**KIRKLEES METROPOLITAN COUNCIL
INVESTMENT & REGENERATION SERVICE**

**DELEGATED DECISION FOR APPLICATION FOR CERTIFICATE OF
LAWFUL DEVELOPMENT**

Reference no.: 2025/CL/93431/W

Site: 11A, Rafborn Grove, Salendine Nook,
Huddersfield, HD3 3UB

EXISTING and PROPOSED PLANS

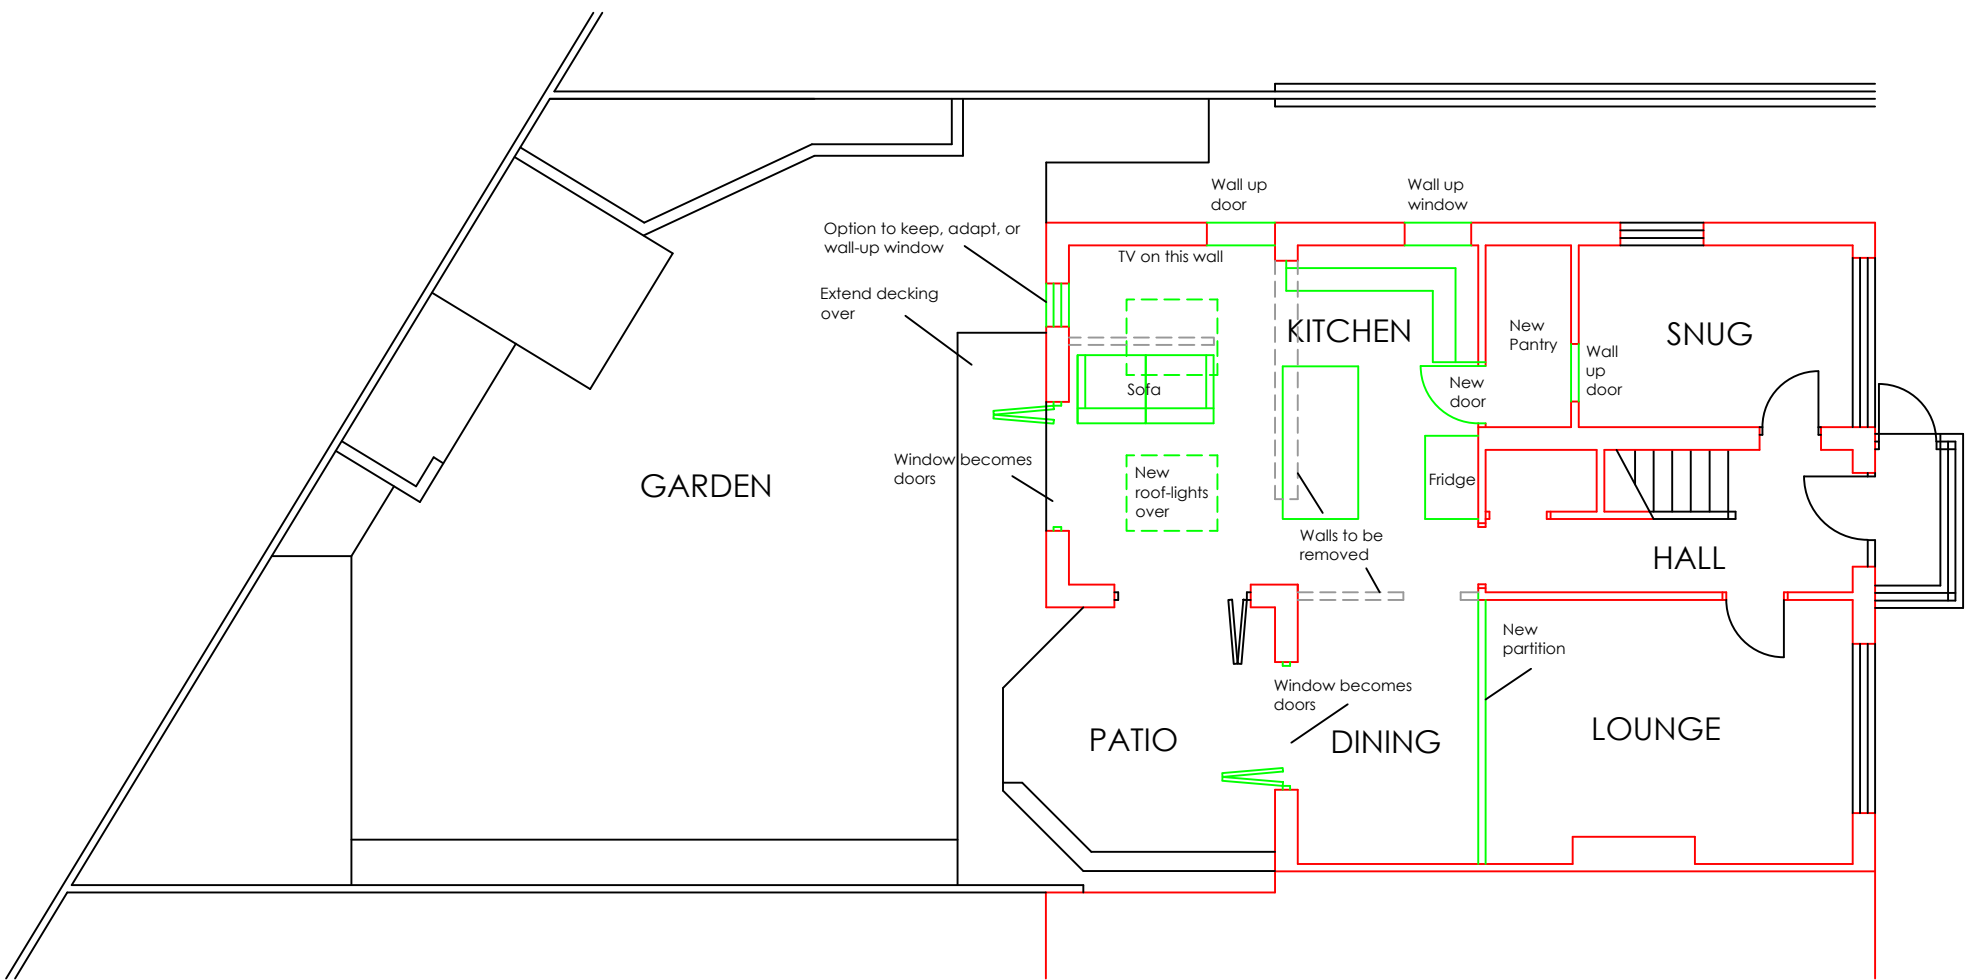
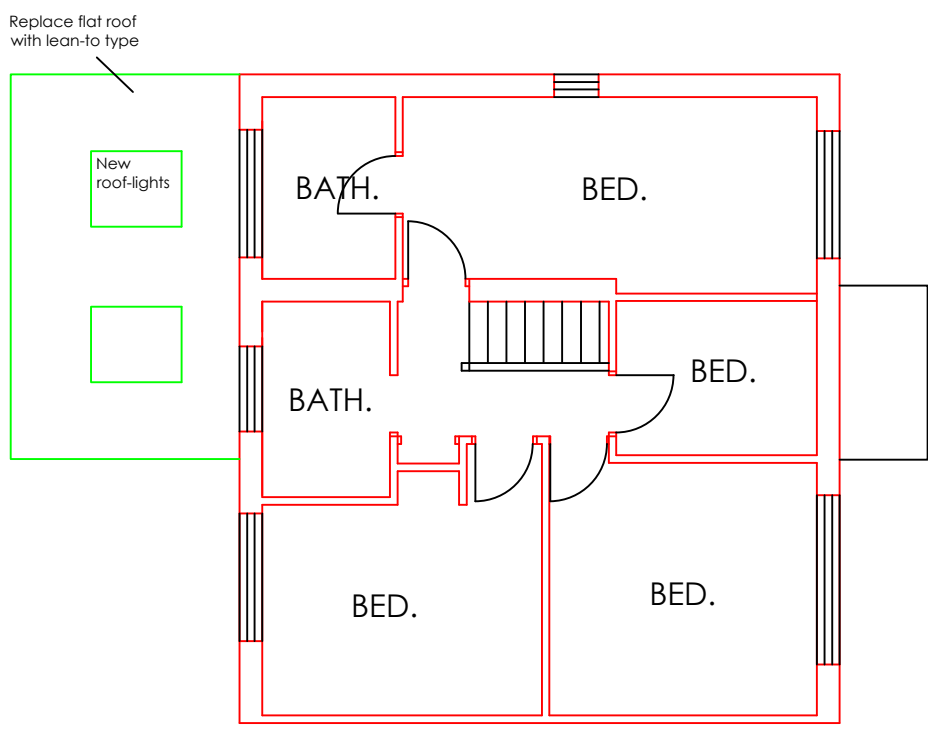
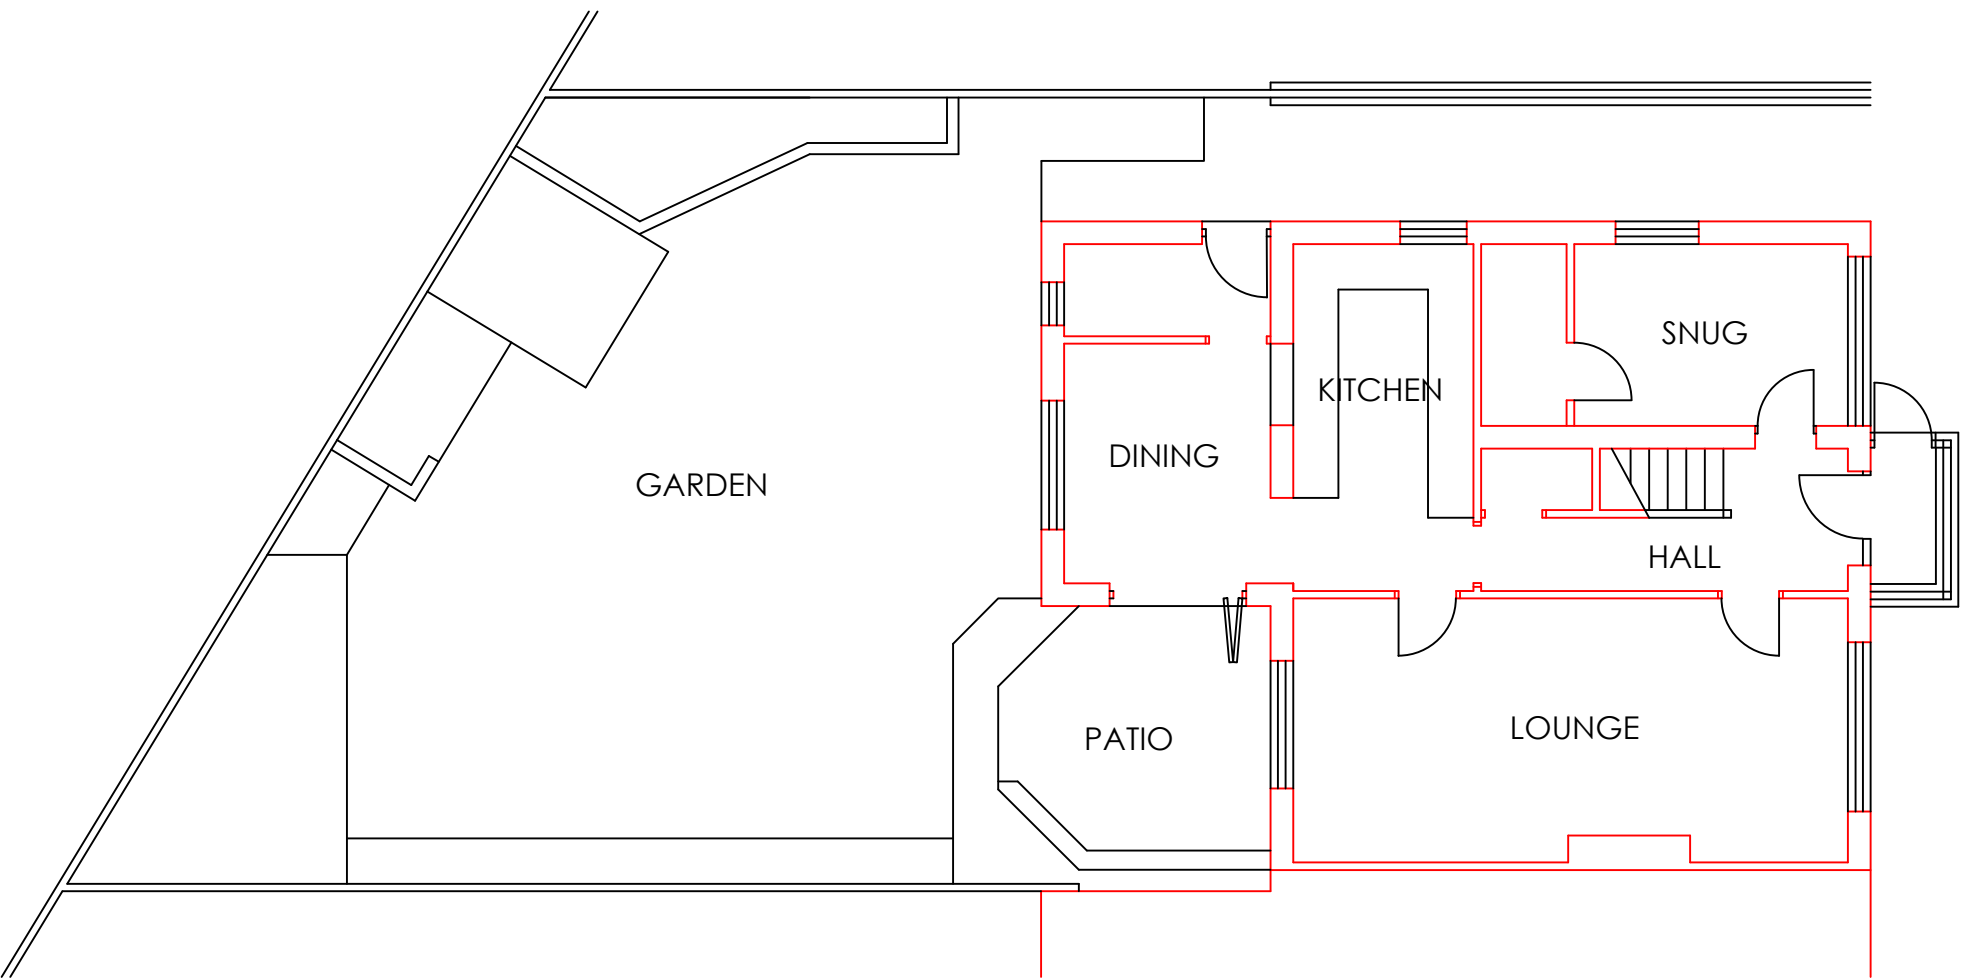
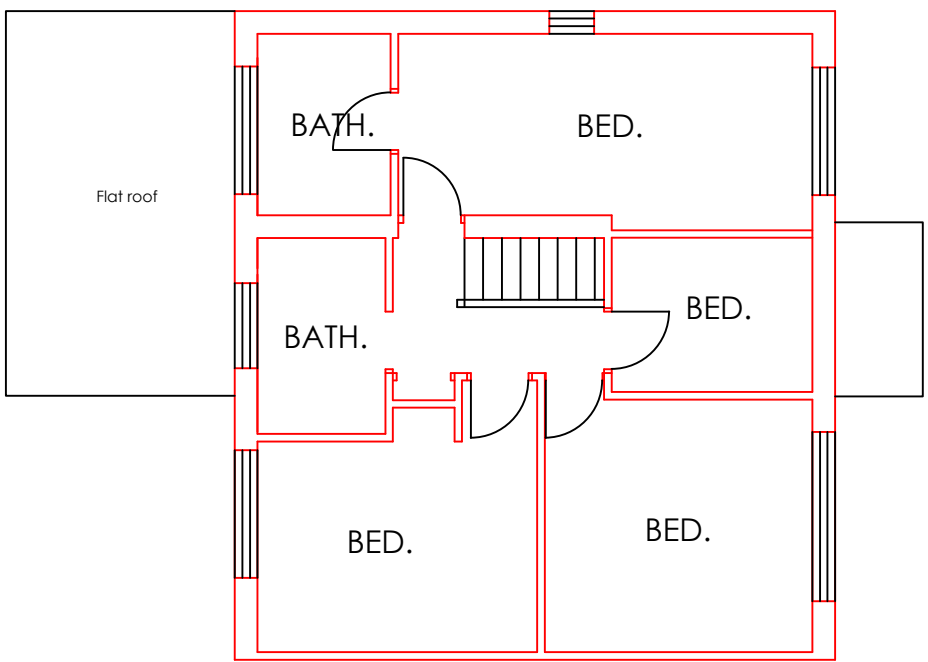
It is also proposed to alter the windows to doors within both the extension and the original rear elevation of the property.

The works to alter the windows to doors within the rear elevation of the original dwellinghouse does affect the external appearance of the building dwelling to a certain degree. However, the works would be to the rear elevation and would have limited visibility from public vantage points due to the layout of surrounding land. In this instance, it can be reasonably considered that to alter an existing opening within the original rear elevation of the dwellinghouse, albeit within a sensitive location does materially impact the external appearance of the dwelling and is considered to be development as defined by Section 55 of the Town and Country Planning Act 1990.

EXISTING and PROPOSED SECTIONS & ELEVATIONS

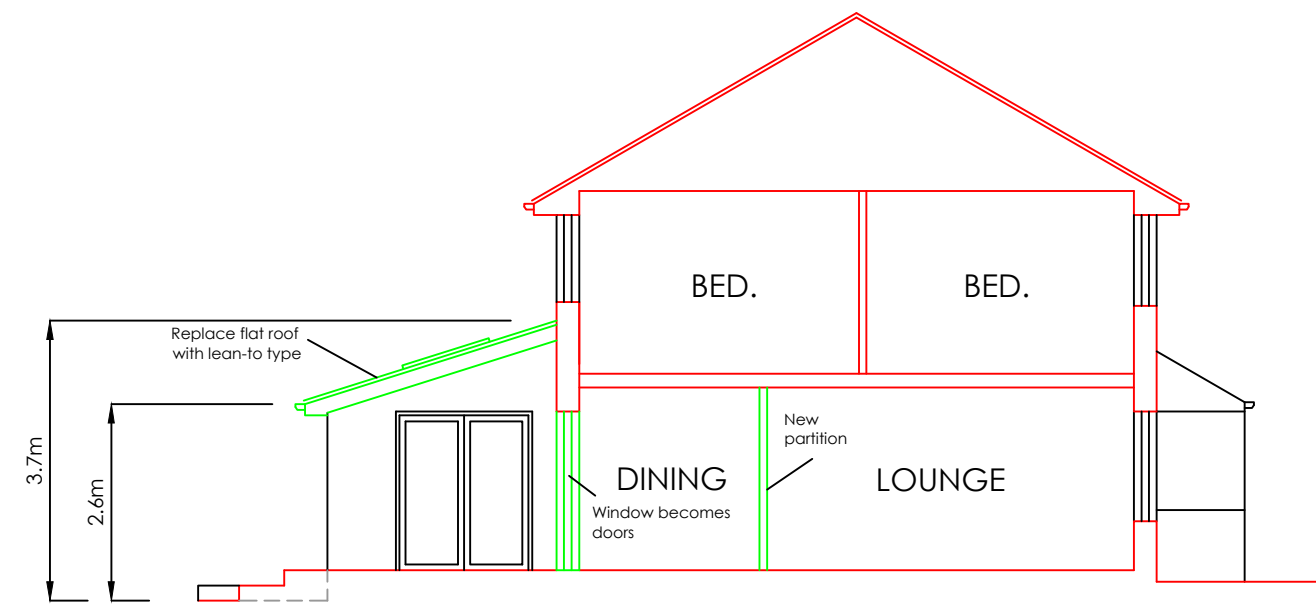
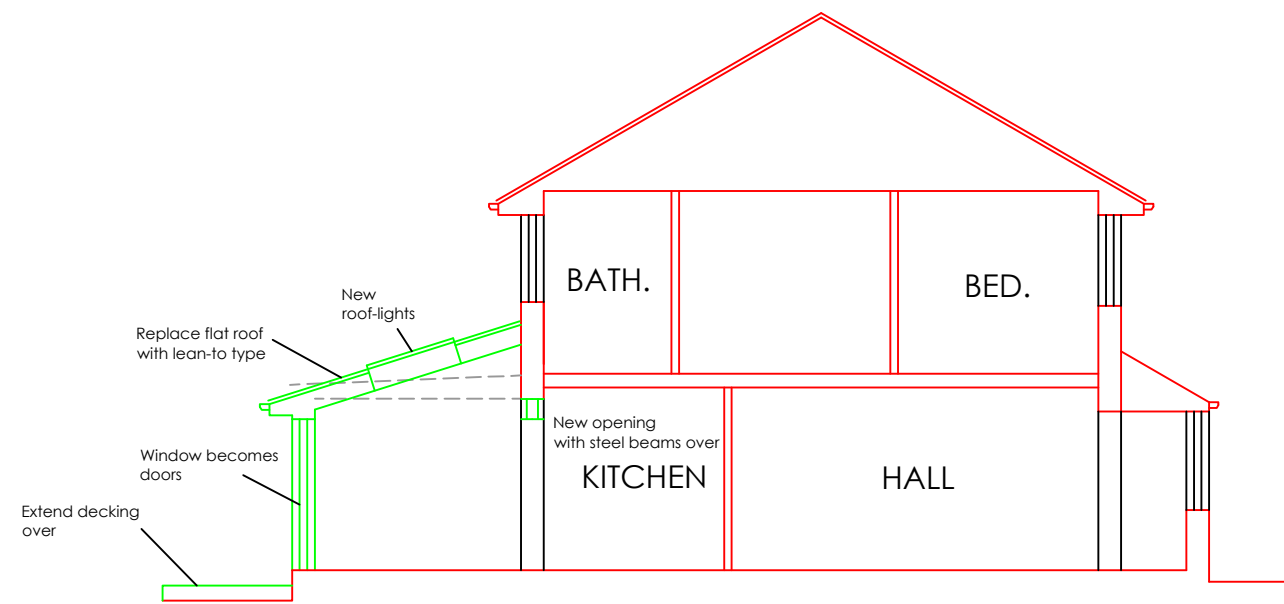
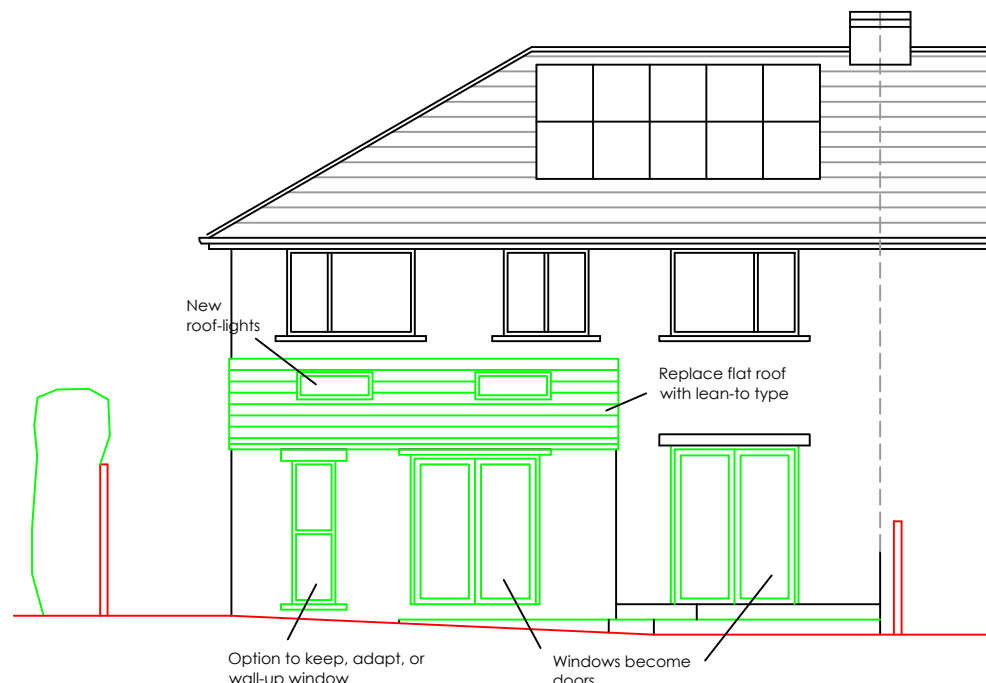
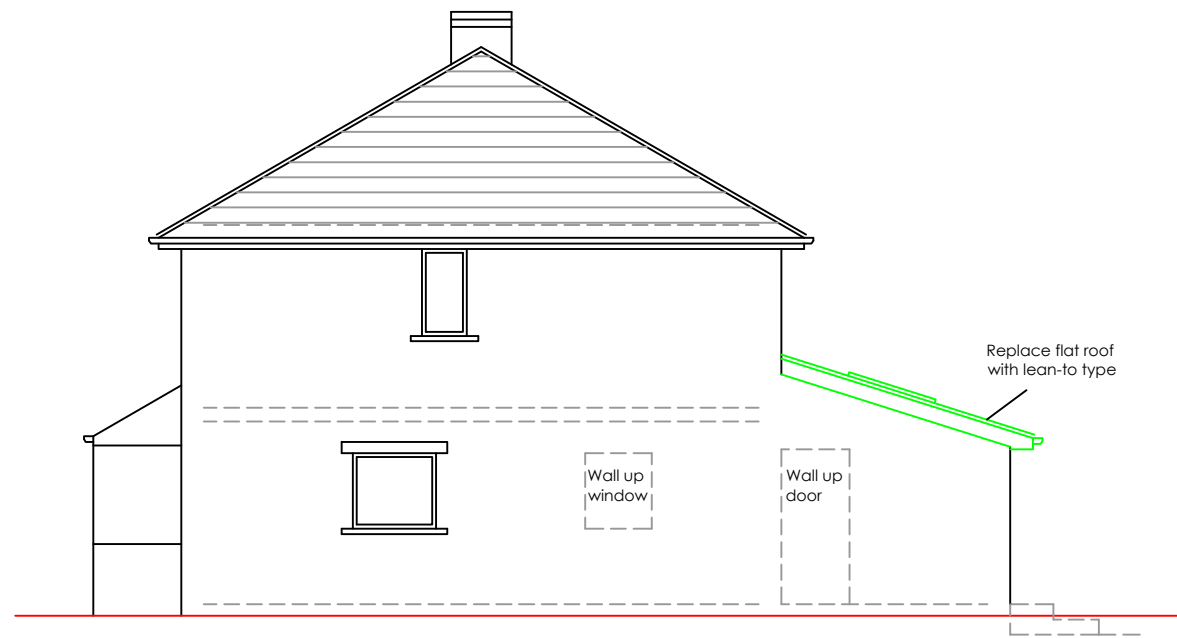
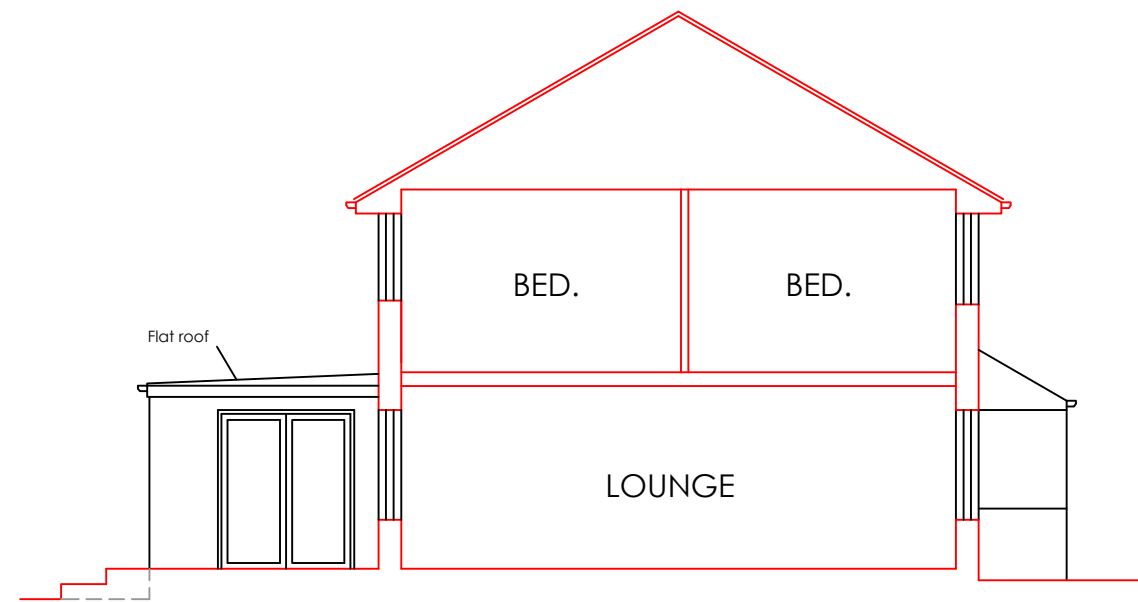
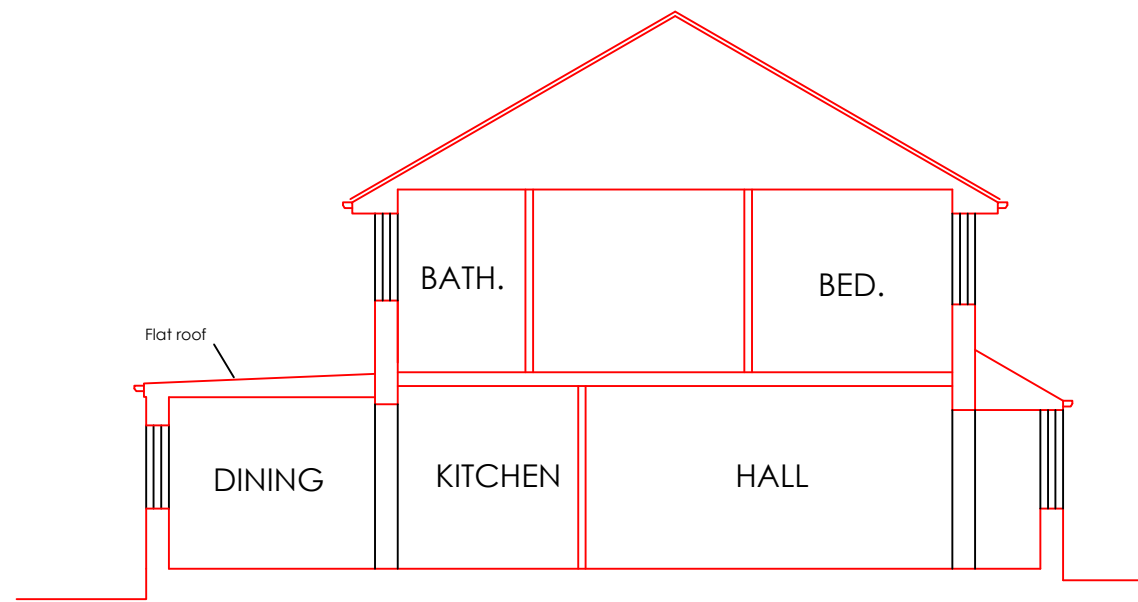
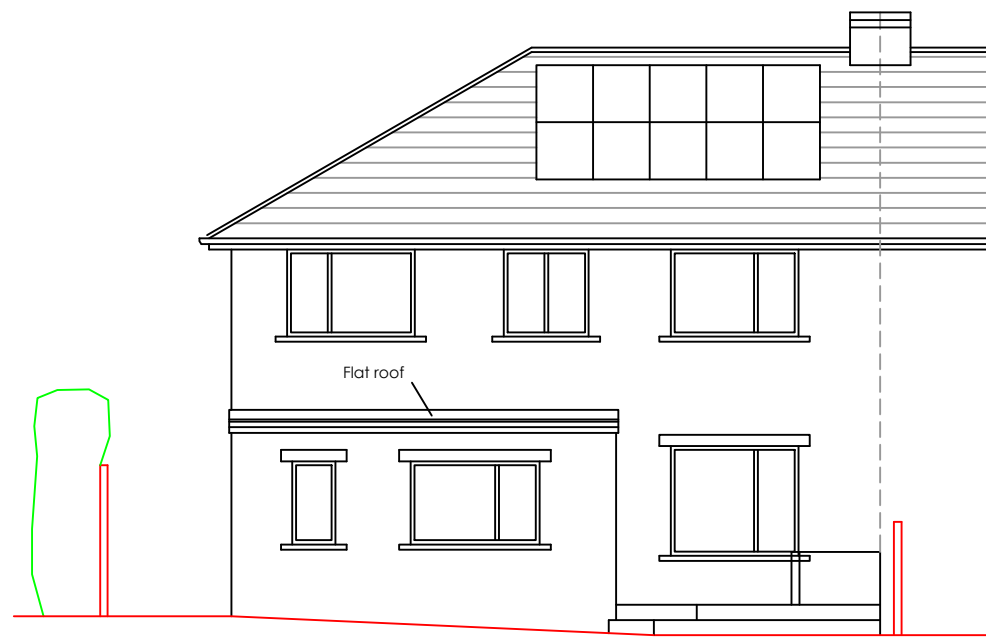
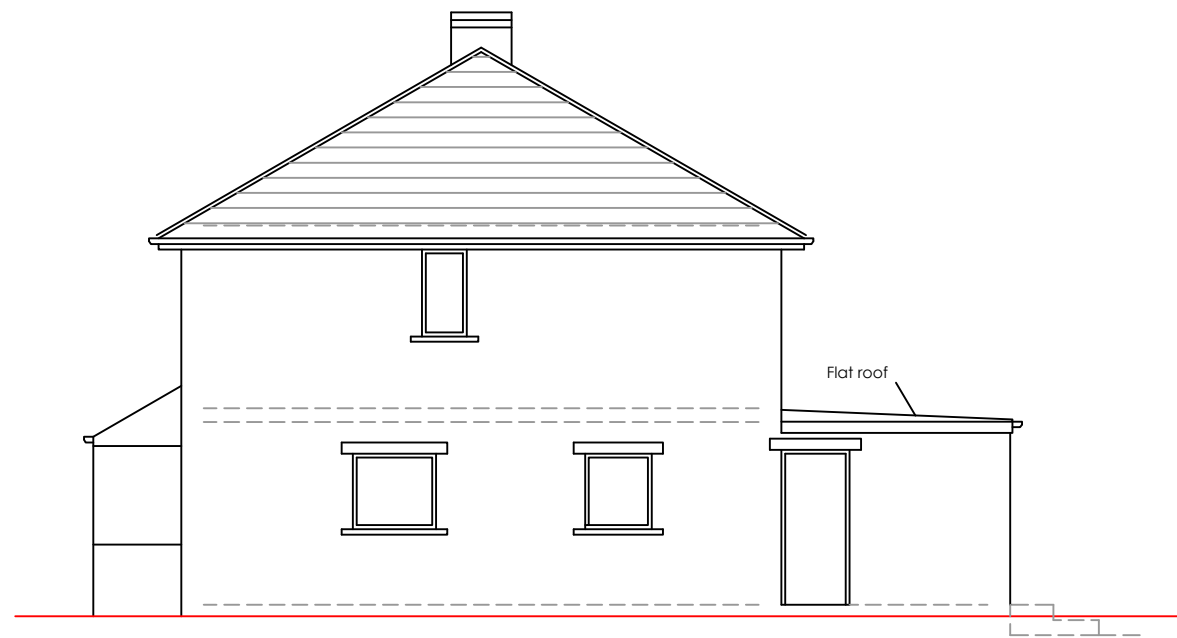
The projection would be retained at 3 metres with an eaves height of 2.6 metres with an overall height of 3.7 metres.

Comment: *The height of the enlargement to the dwellinghouse would not exceed the height of the highest part of the roof of the existing dwellinghouse.*

Comment: *The height of the eaves part of the enlargement would not exceed the height of the eaves of the existing dwelling.*

Comment: *An alteration to the existing roof of the single storey projection is proposed. However, the Government's Technical Guidance states that where an enlargement "includes works that would require an alteration of the existing roof of the house, the alteration to the existing roof of the house will need to meet the requirements of Class B or C." In this instance the enlargement of the roof would not exceed the limitations in Class B of Part 1 when considering the existing addition to the roof space by virtue of the first floor enlargement in terms of cubic content.*
